Sydney Catholic Schools

#### Re: Marist Catholic College North Shore (SSDA-10473)

We refer to DPIE letter dated 20.12.2021 Response to Submissions and SDRP Third Review in response to State Significant Development Application for Marist Catholic College North Shore and specifically comments raised in relation to the Architectural design.

#### **RESPONSE TO DPIE**

Title
GA PLAN - LEVEL 1 ZONE 2

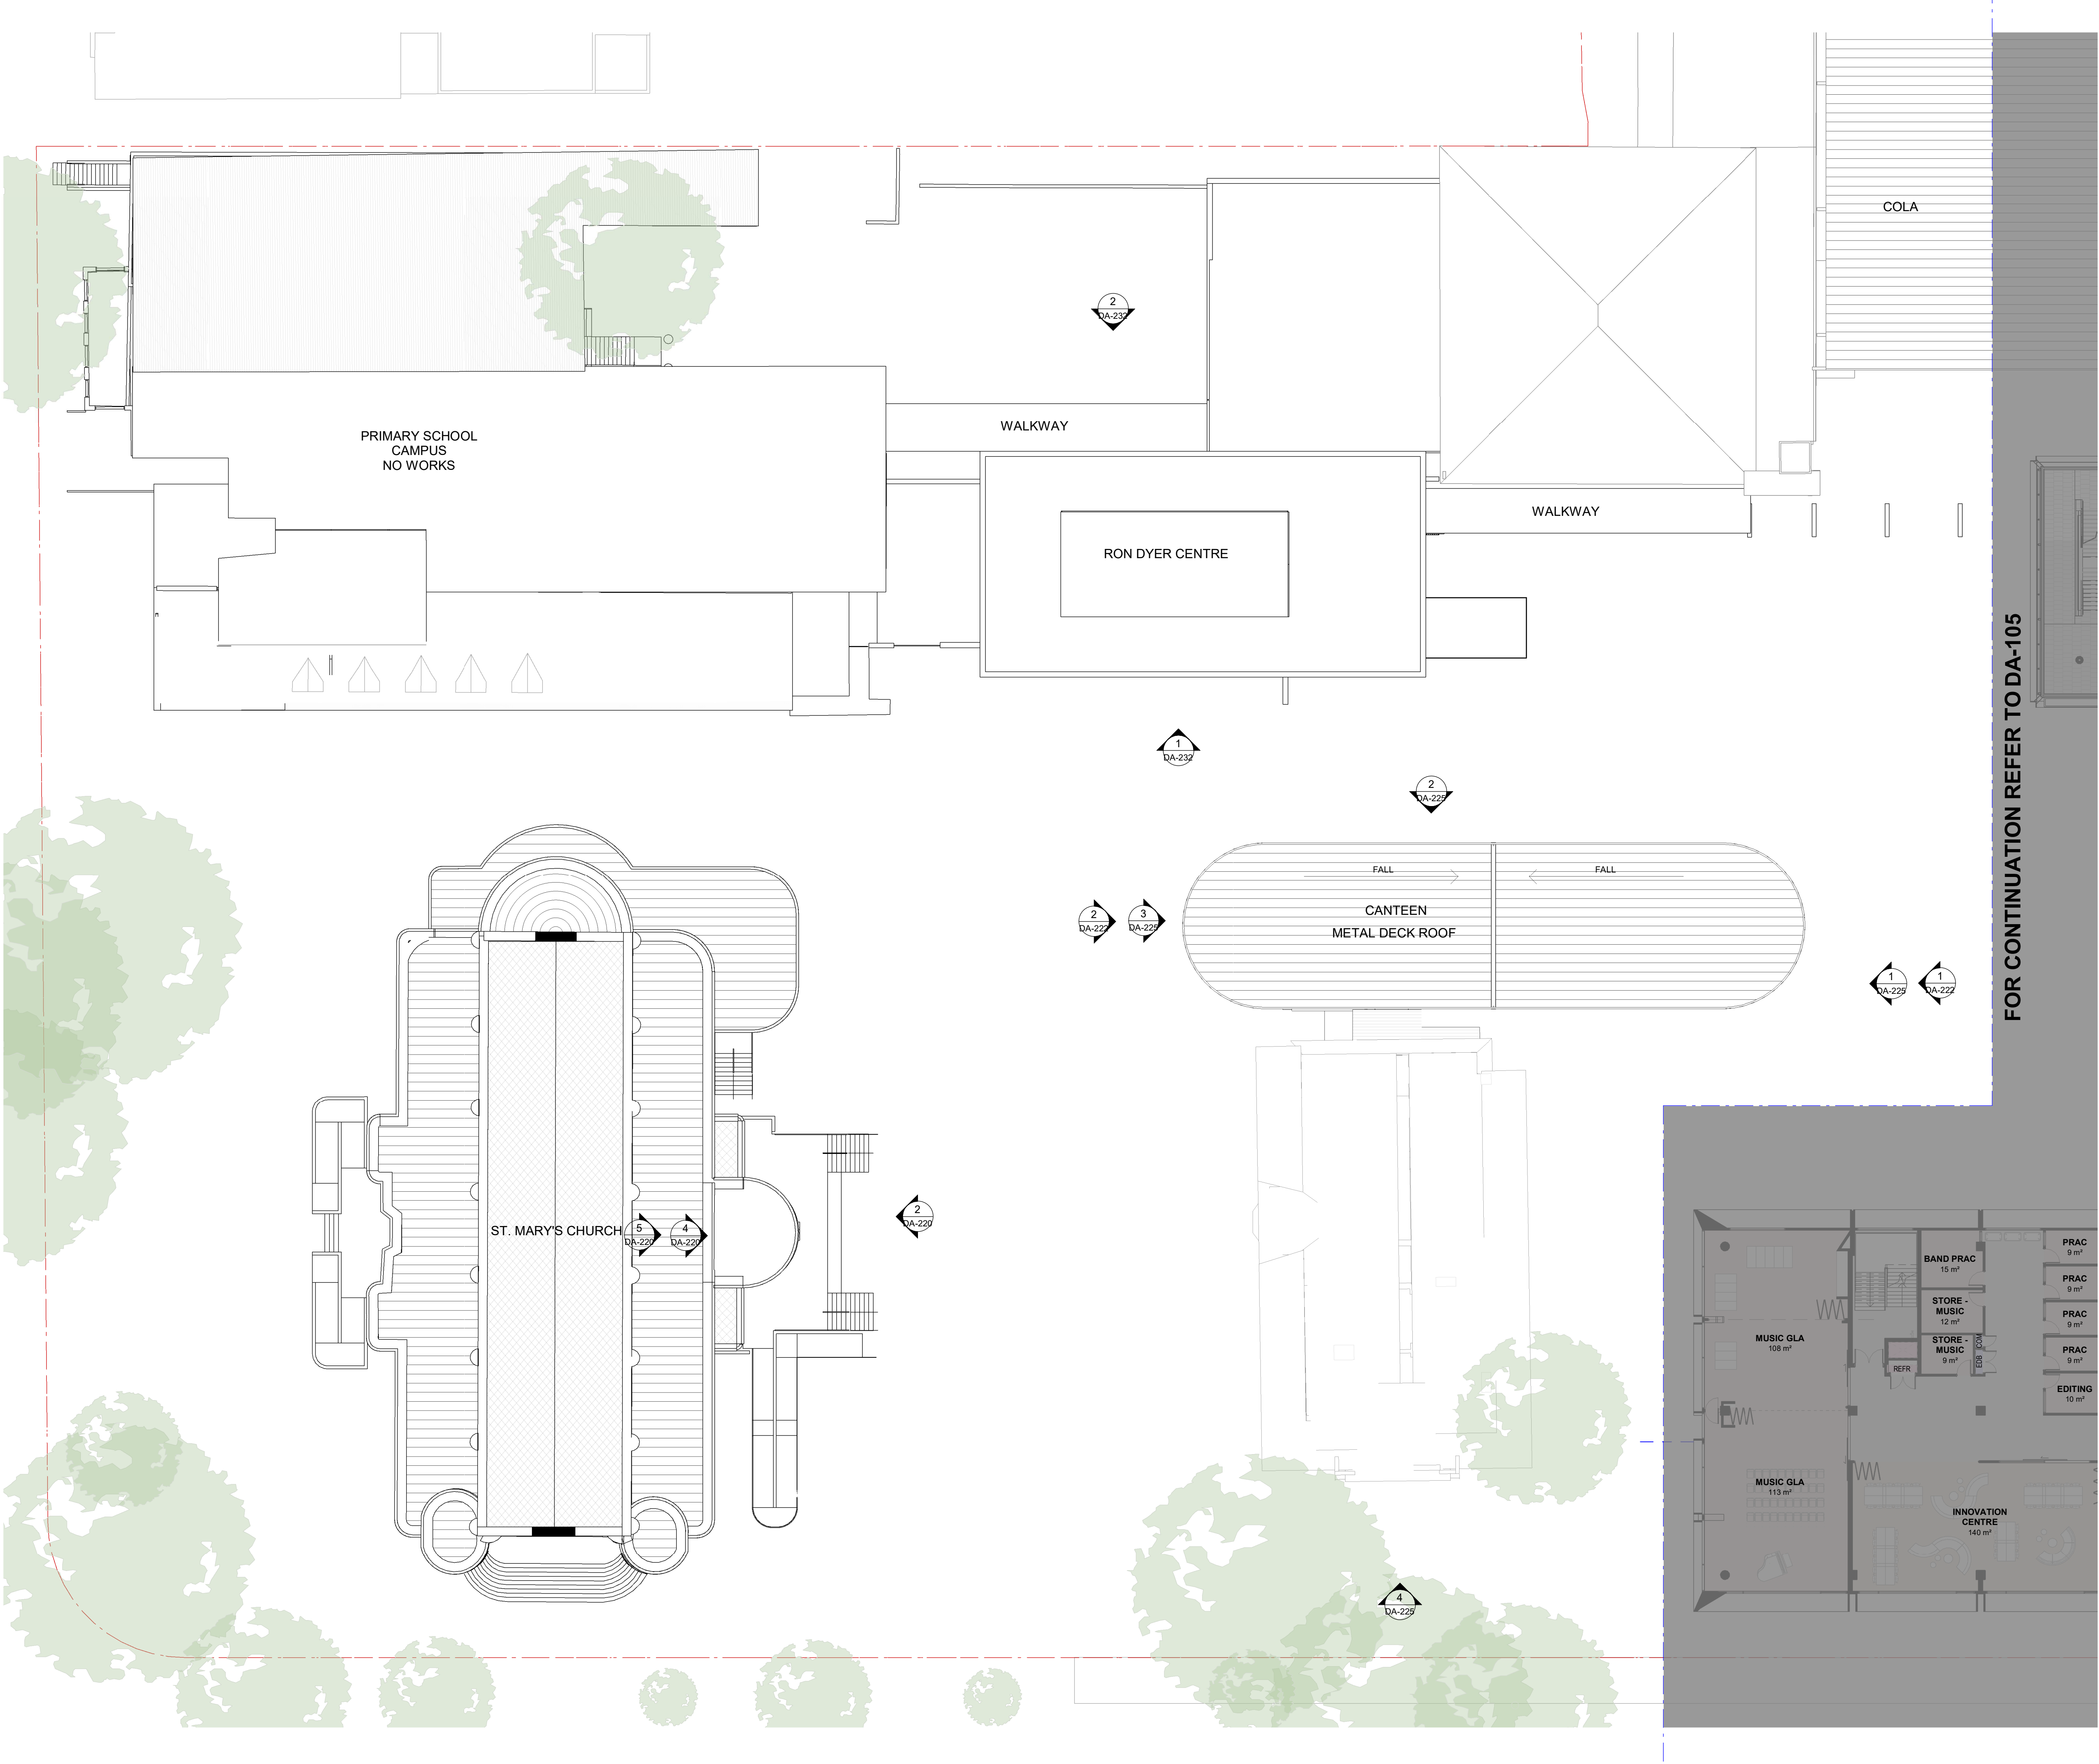
Provide a secure lobby space between the lifts and the entrance to the child care centre in order to enable controlled access.	Refer to DA-101 -GA PLAN - BASEMENT ZONE 2 and DA1-5 - GA PLAN - LEVEL 1 ZONE 2 A dedicated lift to the childcare has been provided to control the access to the

learning floor. This lift cannot access any other floor apart from the Child Care and the Miller St. entry and vice versa. Furthermore, a secured, dedicated lobby has been provided for this lift as an additional secured line for children exiting the lift. Please see Appendix F - Traffic and refer to Deliver a safe and effective pedestrian and vehicular traffic strategy and demonstrate Transport Impact Assessment (by others) how the shared zone will be used at dropoff/pick-up times and during school hours. There is a conflict between students using the proposed shared zone and vehicles entering and exiting the Ron Dyer Centre basement carpark.

1 TEMPORARY BUILDING PLAN
SCALE 1 : 400

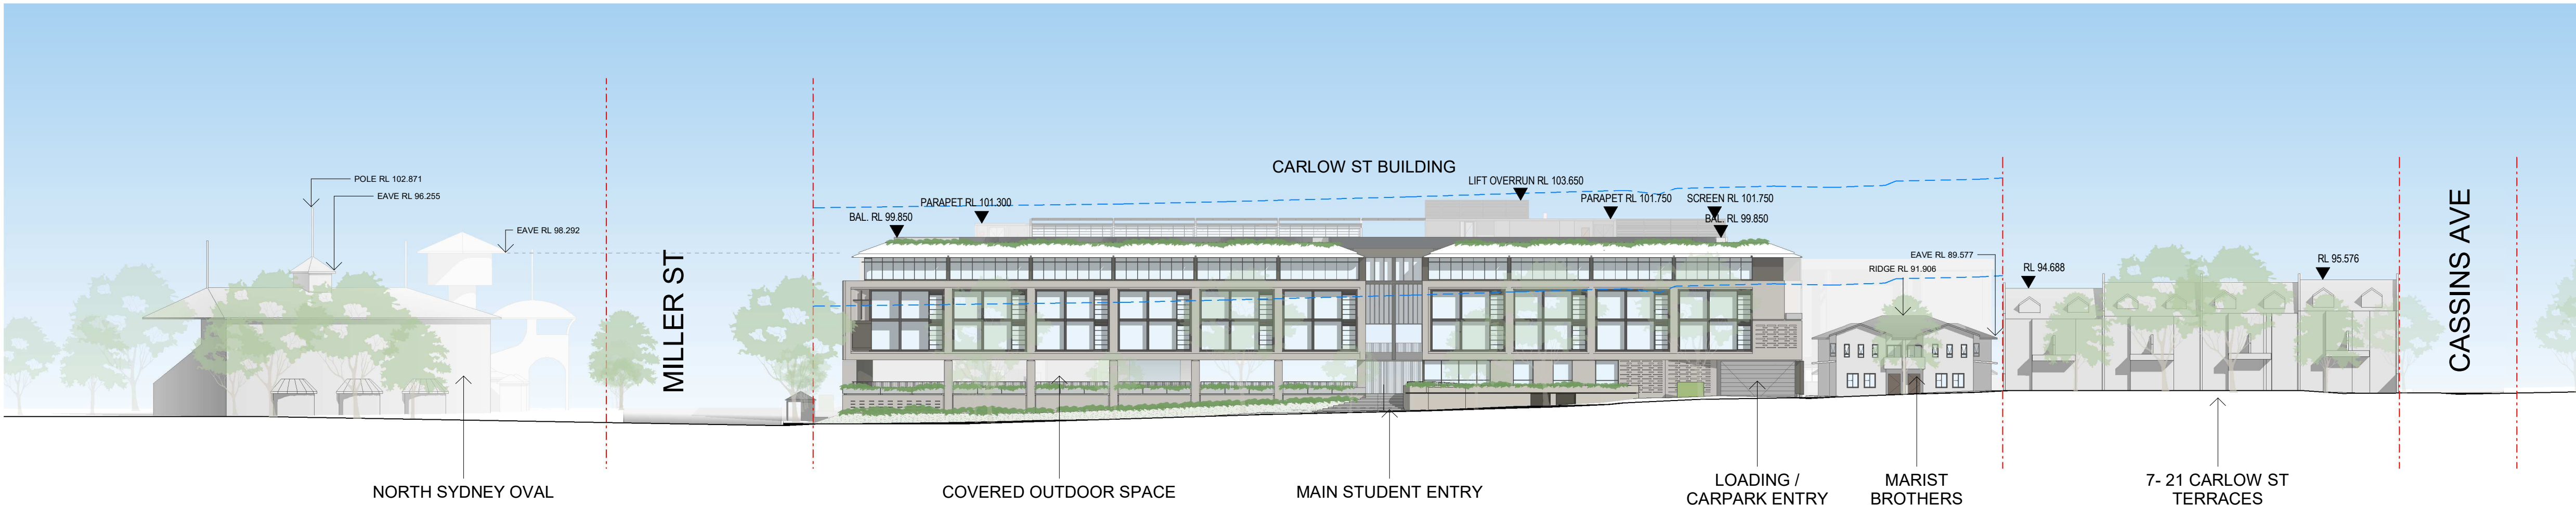
۱ ۱
updated DA-802 (CGI) to reflect the RtS amended Miller Street building. include a temporary building plan and elevation(s) for the proposed portables / temporary classroom(s) etc during construction. In addition, confirm the predicted life-span of the temporary buildings and the trigger/timing for their removal. include the entire site in the updated drawings. Currently the drawings do not show school buildings / structures at the western extent of the site adjacent to Cassini Avenue or the proposed internal changes to Block F. provide a roof plan for all buildings shown on drawing DA-104. delete all details of potential future buildings from the drawings and replace with the proposed or retained arrangement. This would be required to be consistent with the statement that "Stage 02A Building + Walkway" is "Subject to Separate Approval". delete the Ron Dyer Centre connection to that future walkway from this application and including it with the Stage 02A future application.	New temporary buildings plan has been included Refer to DA-112 - Temporary Buildings Plan Extend of works towards the western portion of site has been clarified. There are no works in this zone Refer to DA-021 - Site (Roof) Plan Roof plan has been included Refer to DA-110 and DA-111 - Roof Plan Zone 1 & 2 Floor plans have been updated to reflect existing arrangement including Stage 2A works and removal of terraces and Jacaranda Cottage.

1 01 MILLER/CARLOW BLOCK - EAST

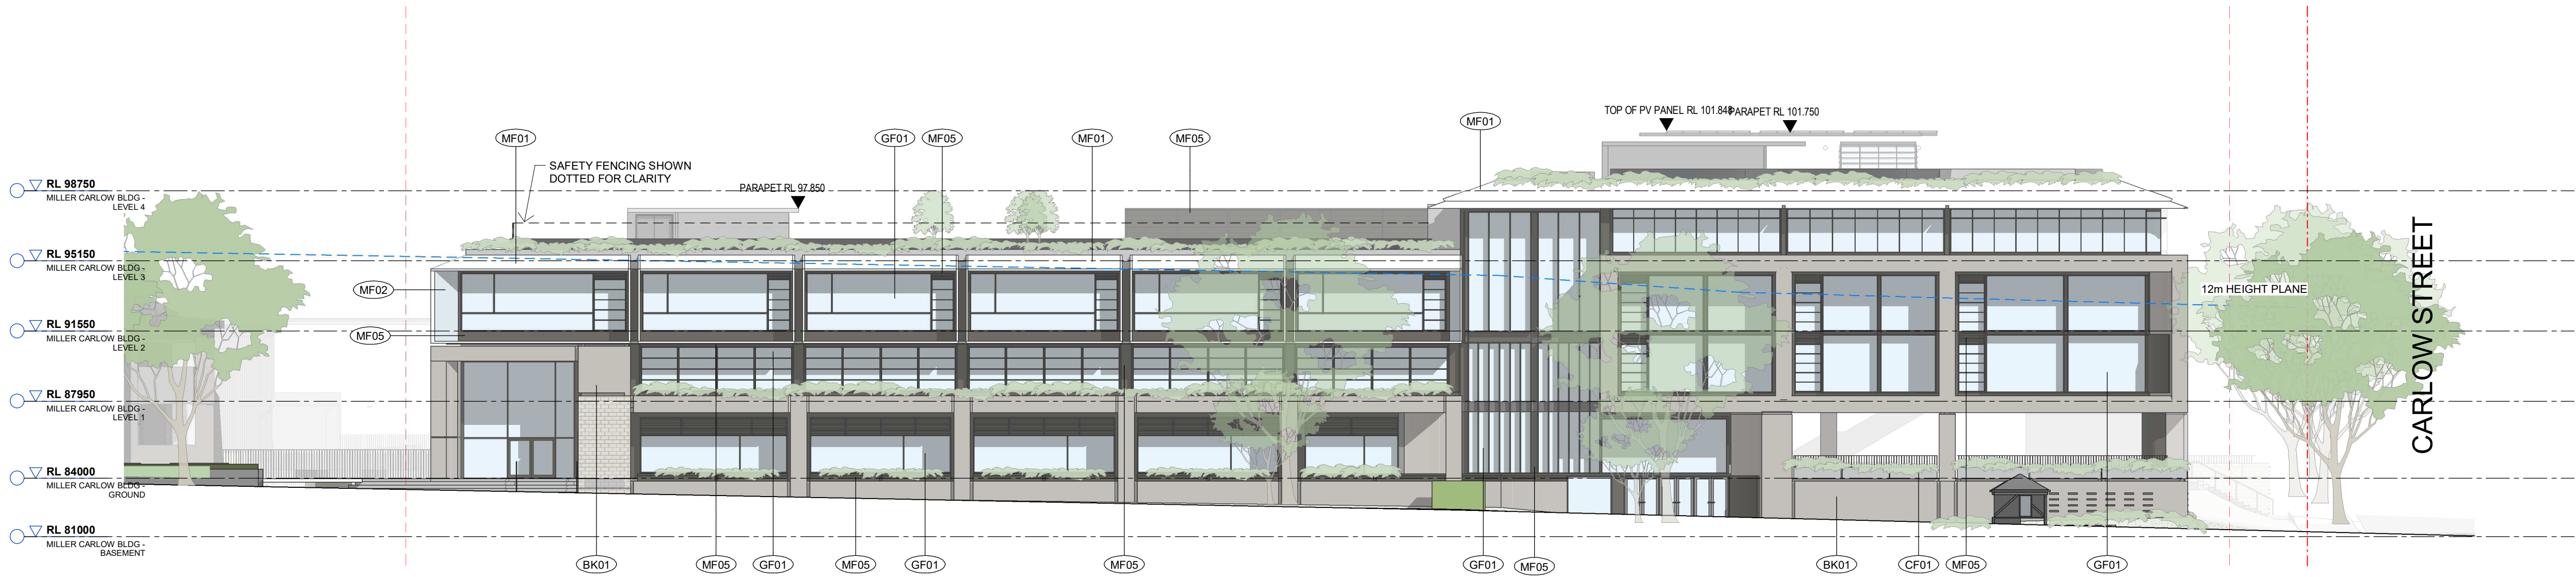
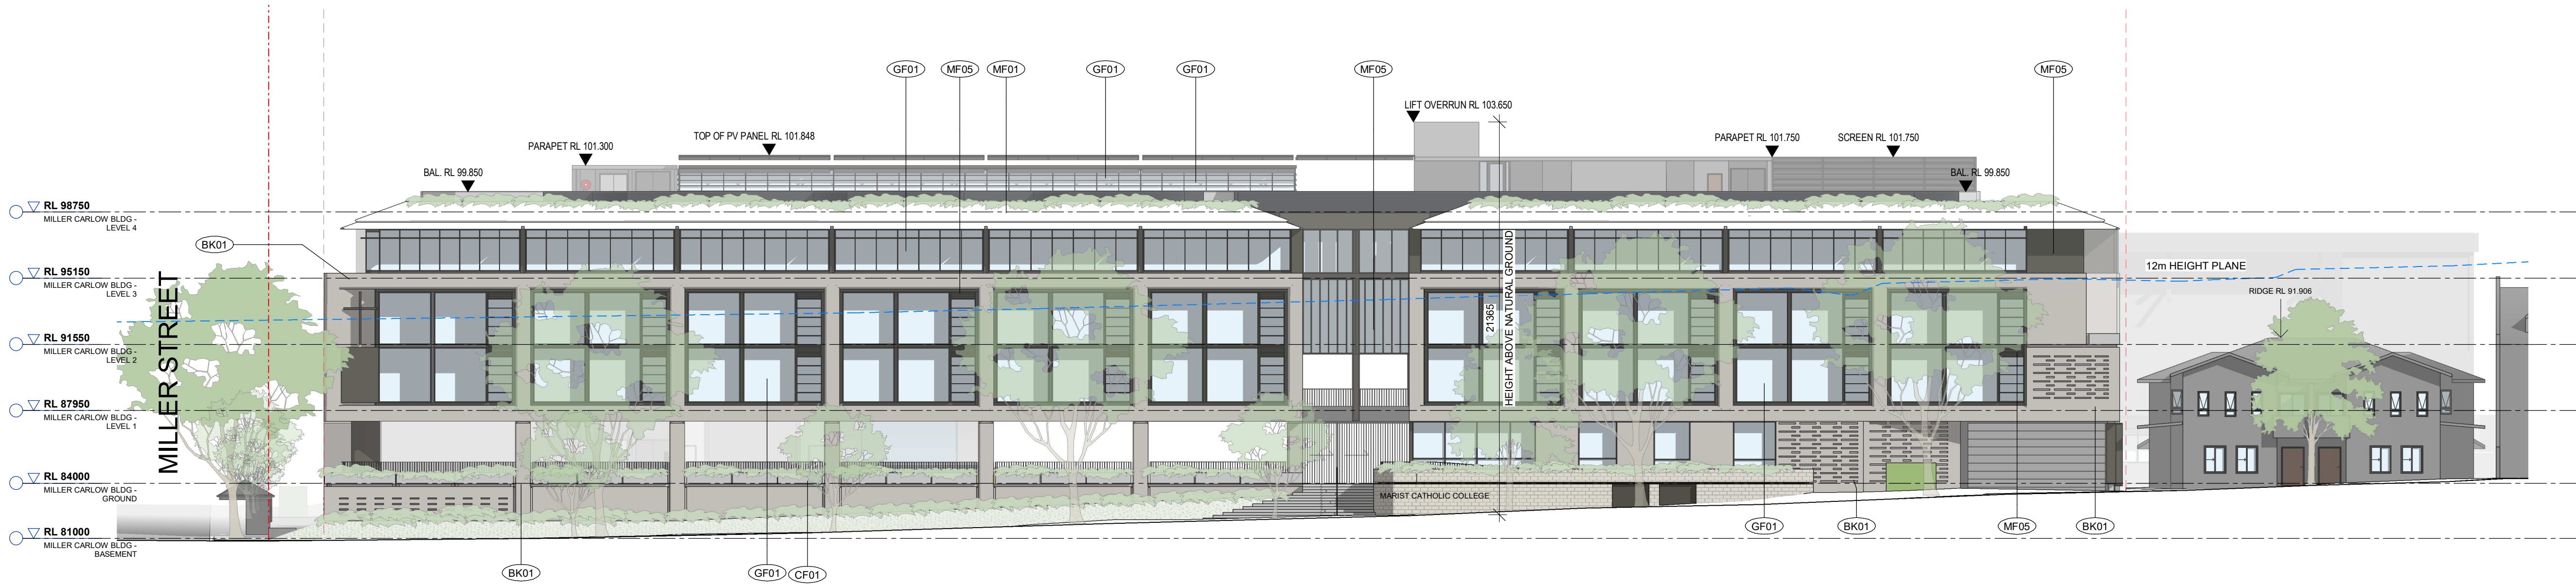
MATTER RAISED	COMMENT
Heritage	
The bulk and scale of the building at the corner of Miller and Carlow Street has not been assessed. The Department has raised this concern earlier and considers that the scale of the proposal at this corner should be reduced. The design should	Refer to Architectural design statement Section 2.0 Architectural response, drawing DA-200 Streetscape Elevations, DA-210 Building Elevations The scale of the building has been reduced by revisiting the design of top floor of the

be revisited with the goal of being able to provide a proposed corner building of a form, that more sympathetically responds to the heritage aspects of the surrounding context. Miller Carlow building. The lightweight metal portal framing around the upper windows has been removed and the glazing line setback from the facade. This has reduced the visual bulk of the top floor. This also emphasises the double storey window frame elements in the brick facade similar to the language of the adjacent North Sydney Hotel. Additional curved brickwork detailing has been added to soften the facade. The main bulk of the facade is maintained within the LEP height plane and is sympathetic to the surrounding context.
